## Development Facilitation Team (DFT) – Review Comments

**Project No: PR-2023-009105 Date: 8/14/2024      Agenda Item: #4      Zone Atlas Page: B-14**

**Request: Major Preliminary Plat & Vacation Easements**

**Location: 10080 & 10088 Coors Blvd NW between Coors Blvd and 7 Bar Loop**

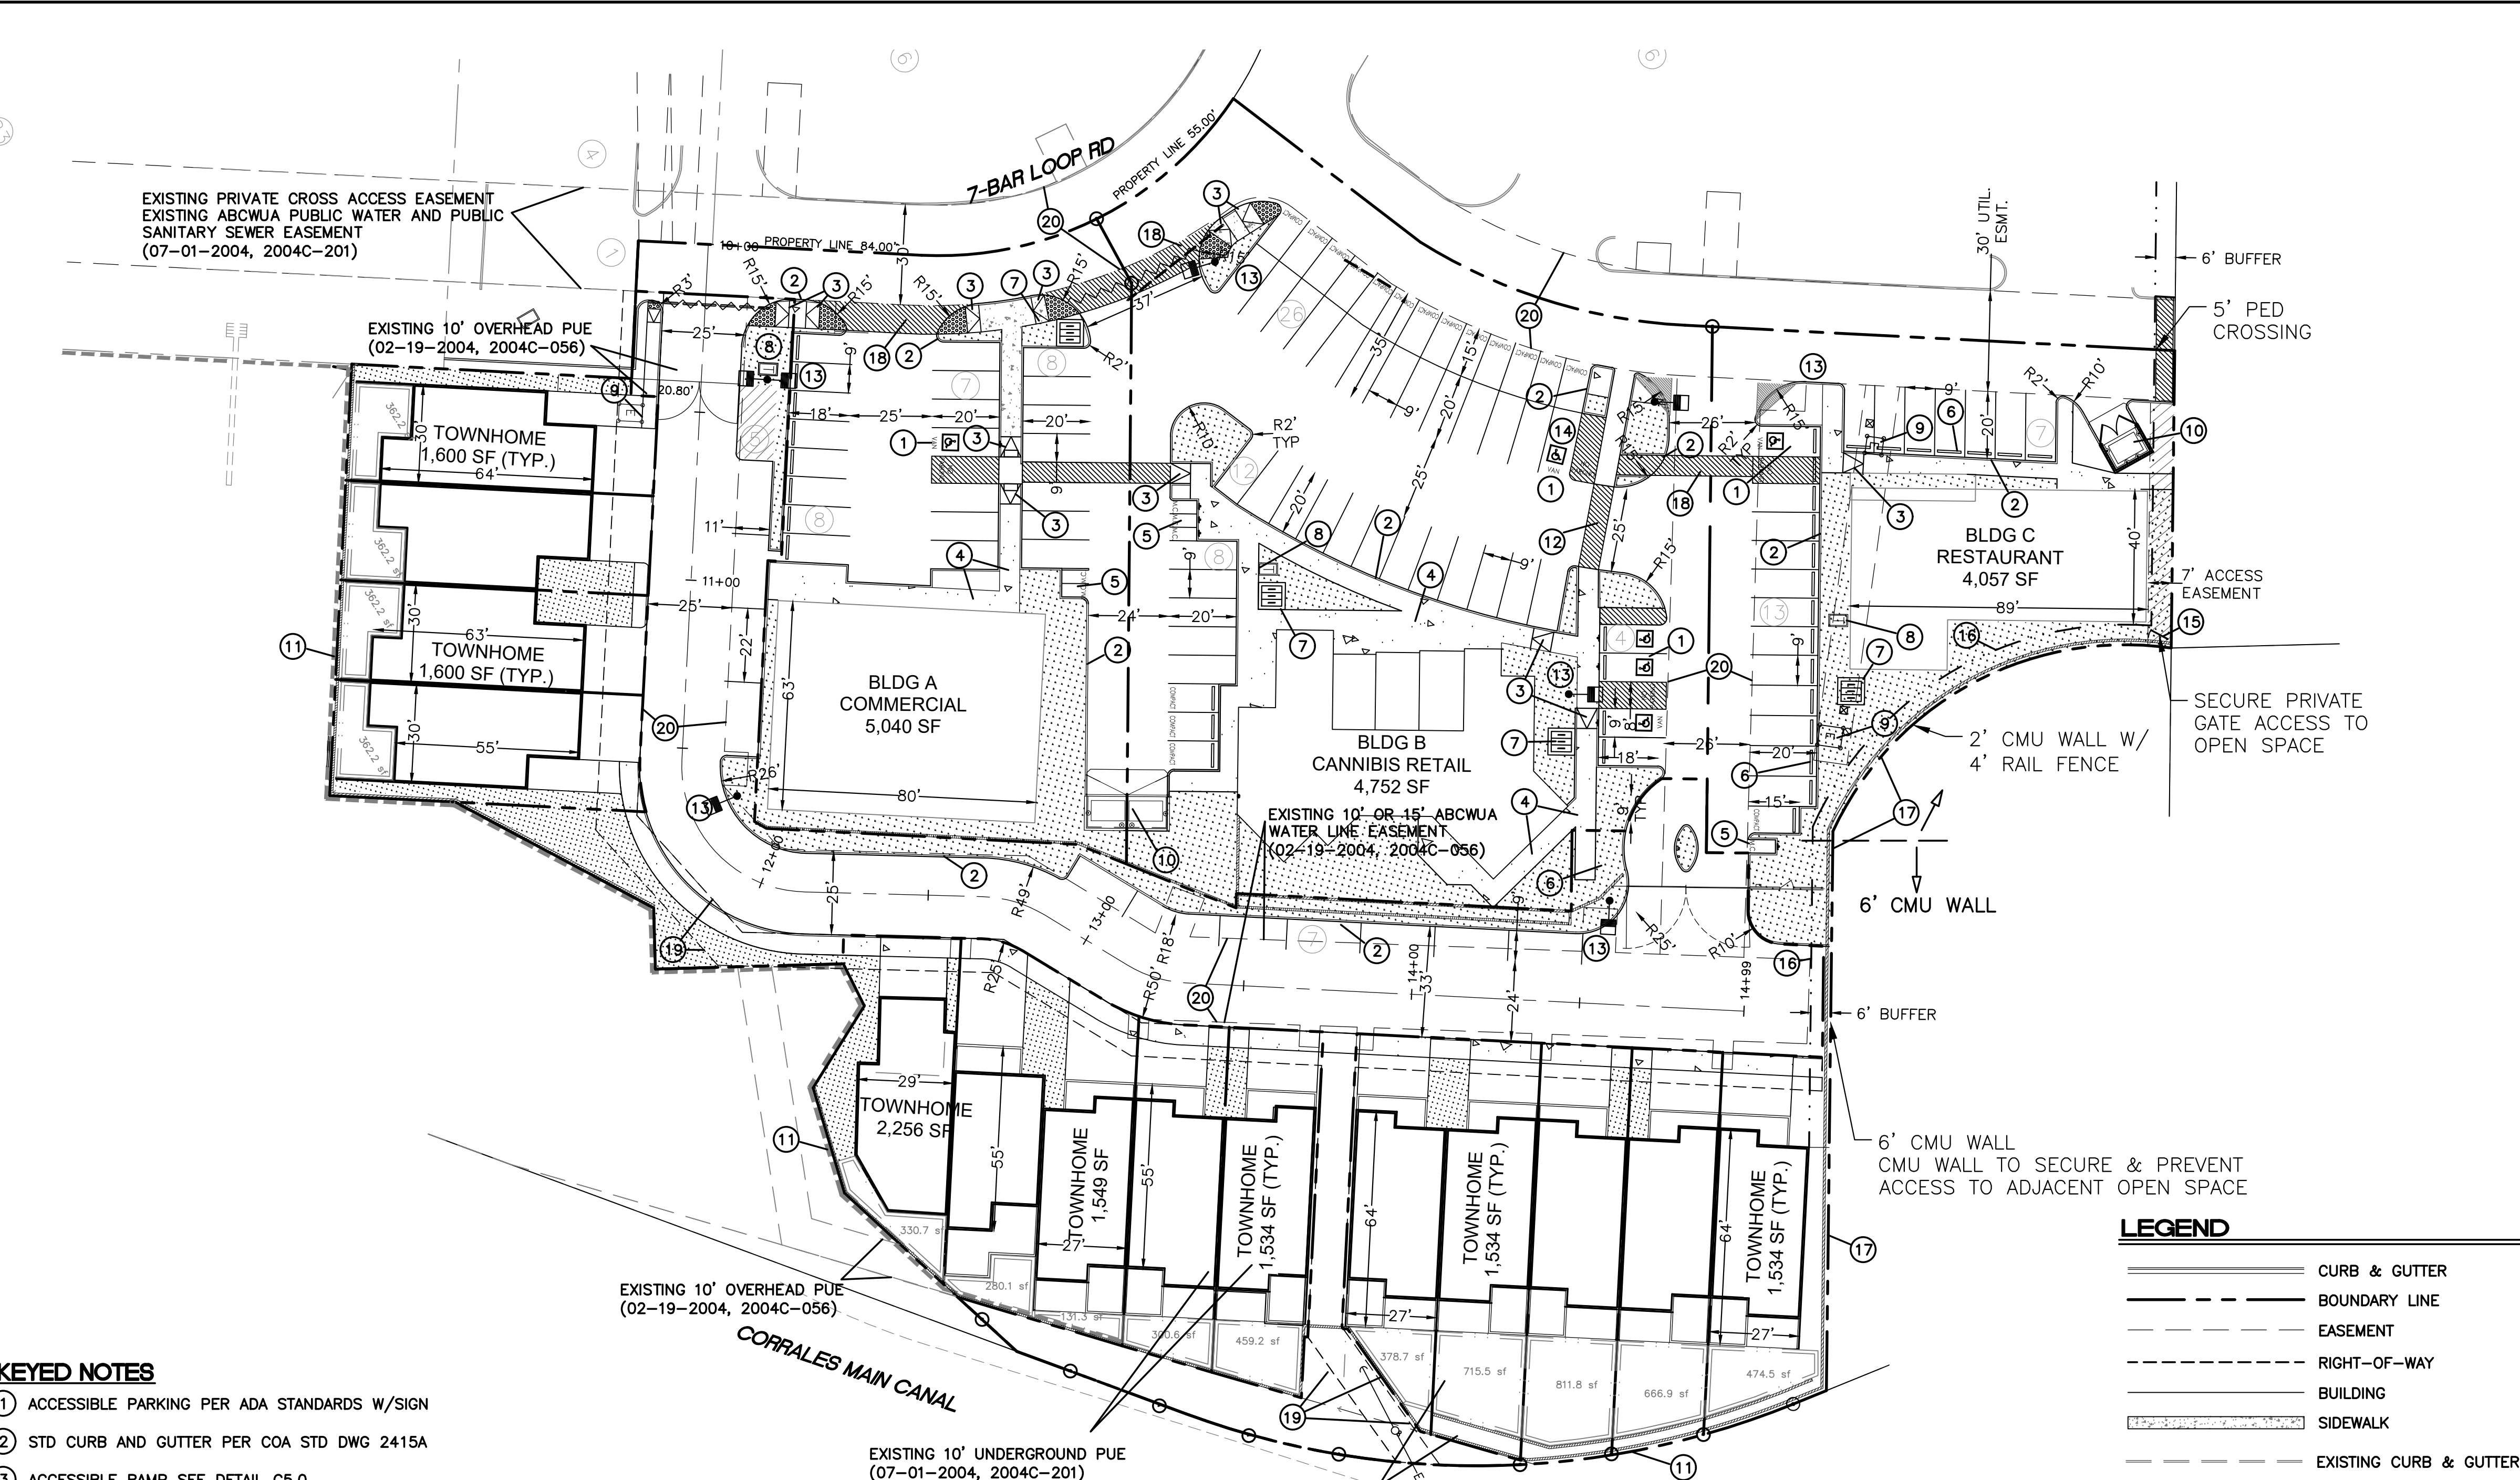
The subject site is adjacent to MPOS and within 330 ft. What was the EPC variance for the MPOS buffer? The IDO requires 45'.

1. No objection to the Vacations.
2. There should be sidewalks internal to the site along the interior roads for ADA access.
3. An approved TCL will be required prior to site plan. Also, a Traffic Scoping Form should be completed and submitted to Curtis Cherne to determine if a traffic study is required..

REMAINING AND NEW EASEMENTS

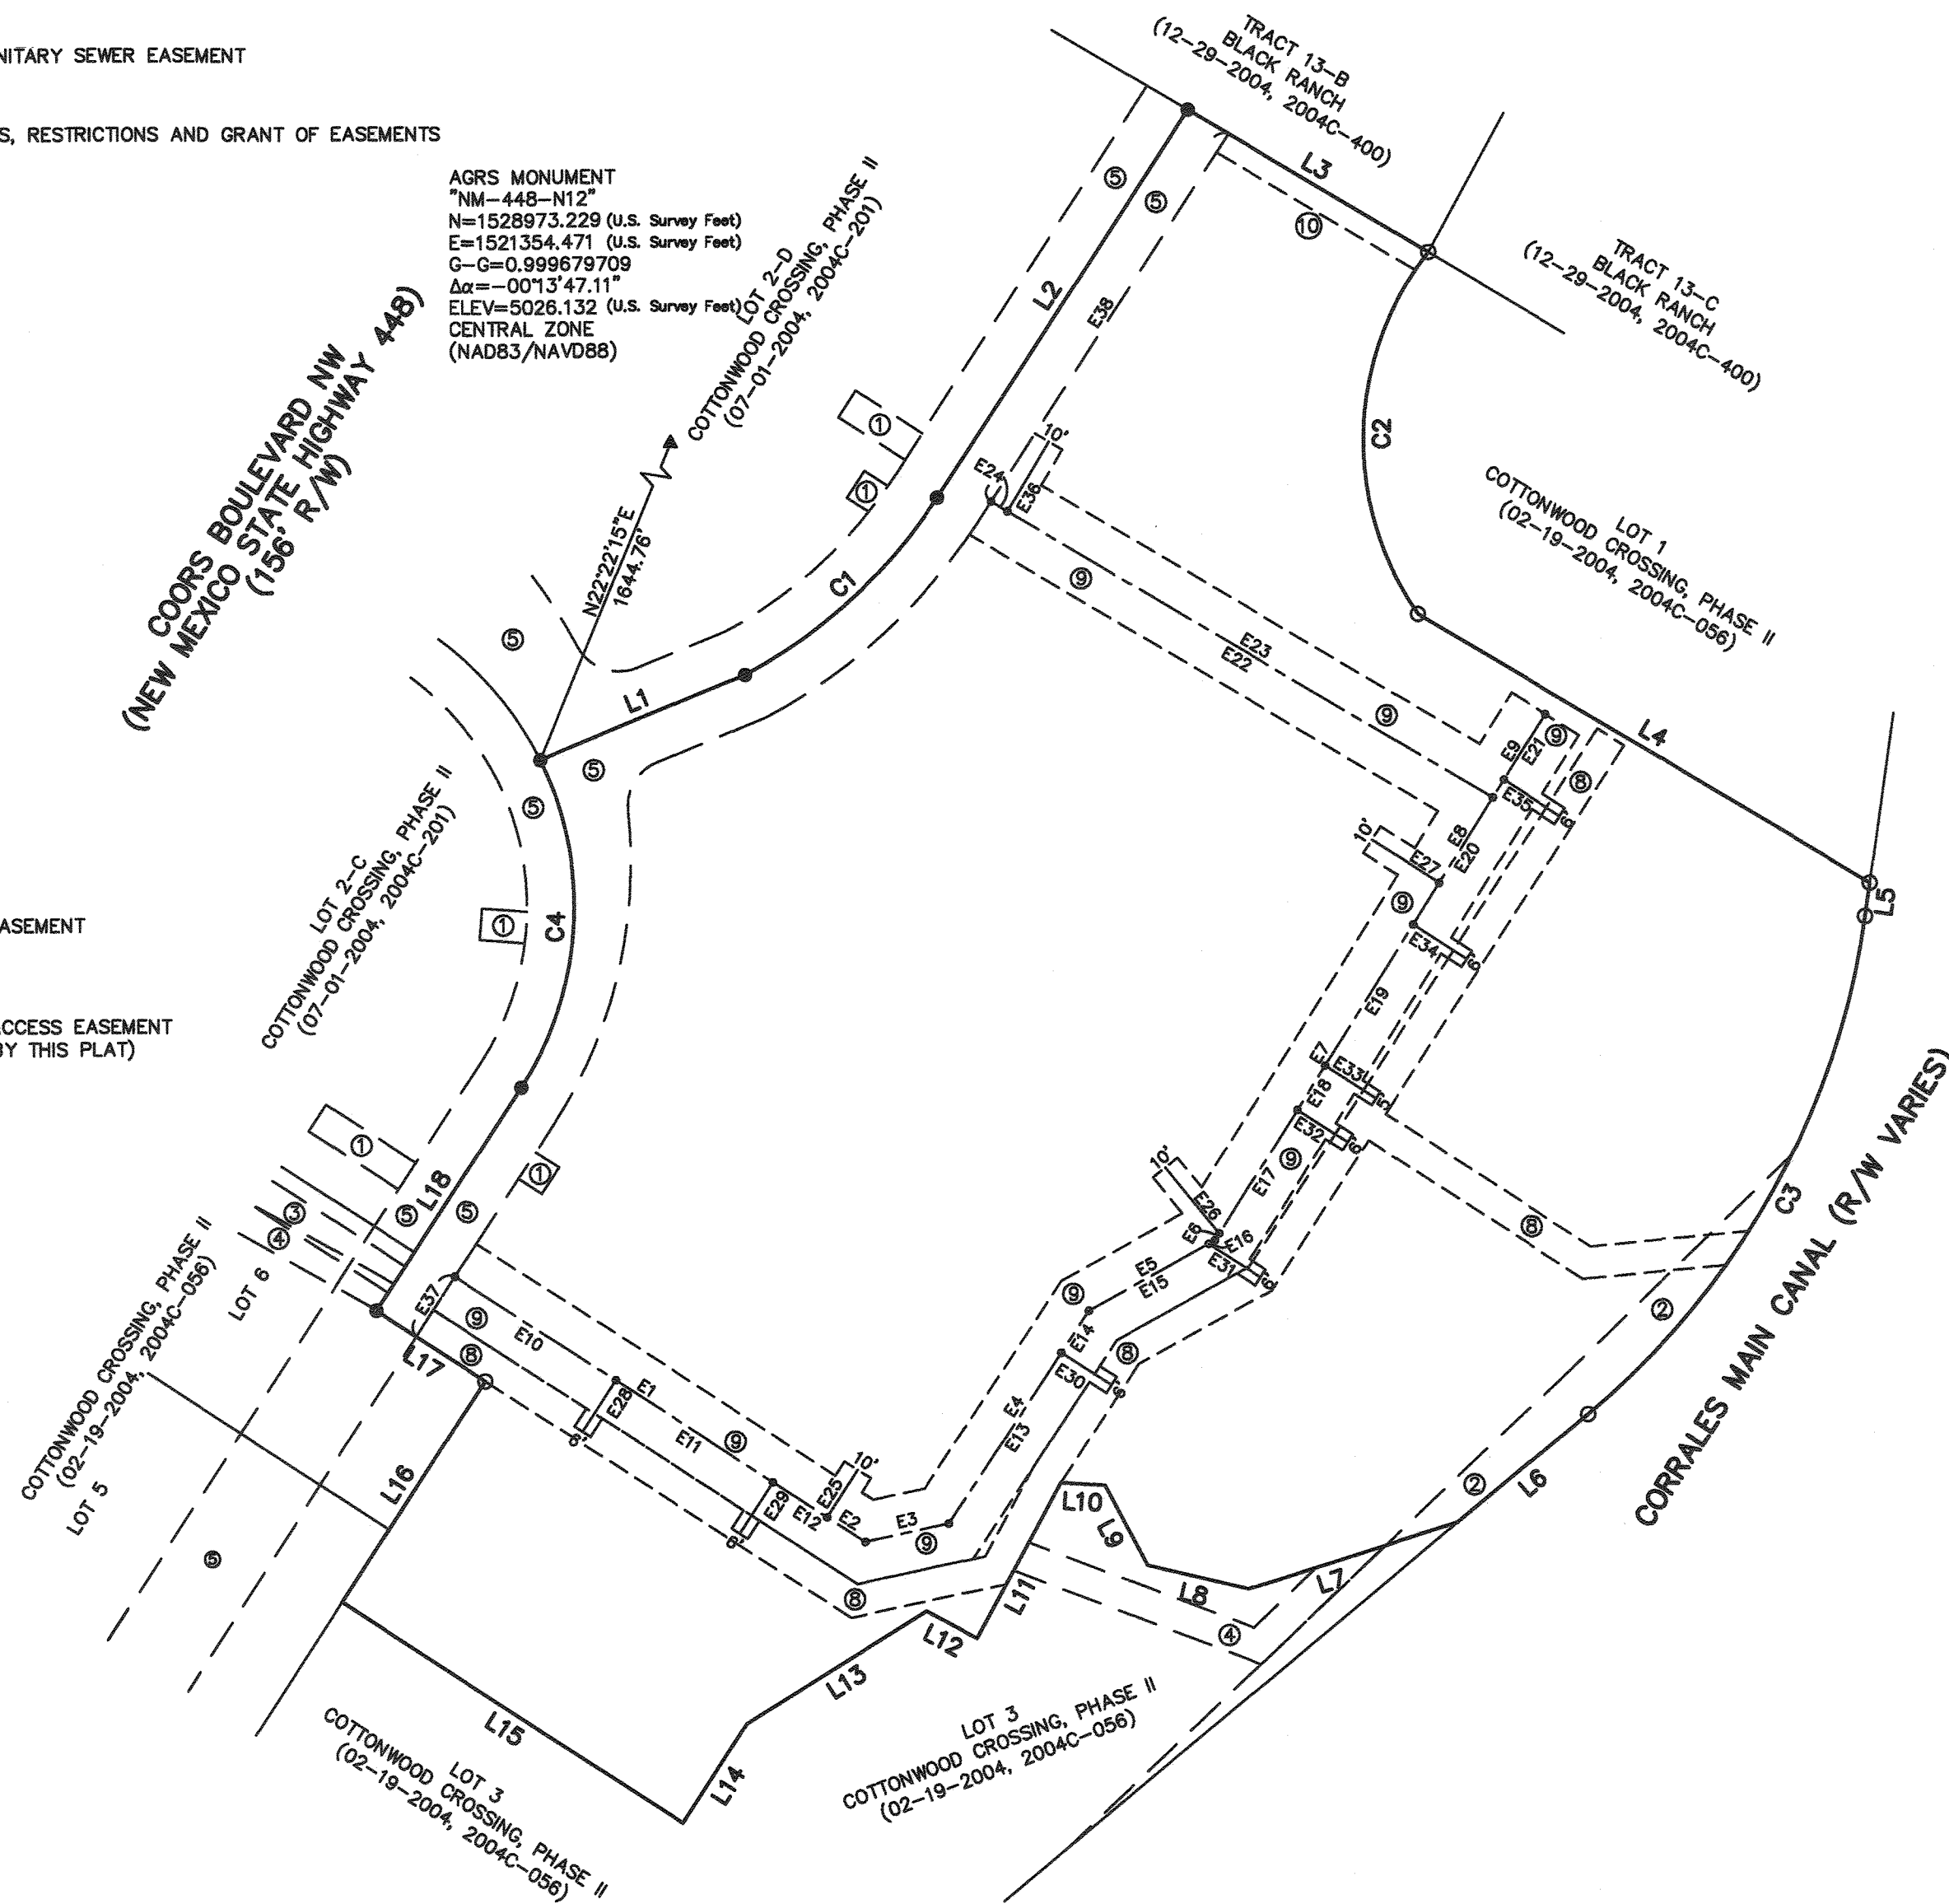
2. Coordinate with NM 811 to field locate and survey the existing public water and sewer infrastructure. If existing infrastructure is not within the existing easements, dedicate additional easements to provide the minimum widths over the actual pipe locations.

- c. Dimension the public water and public sewer easements on the utility plan.
  - d. Coordinate with NM 811 to field locate and survey the existing public water and sewer infrastructure. If existing infrastructure is not within the existing easements, dedicate additional easement to provide the minimum widths over the actual pipe locations.
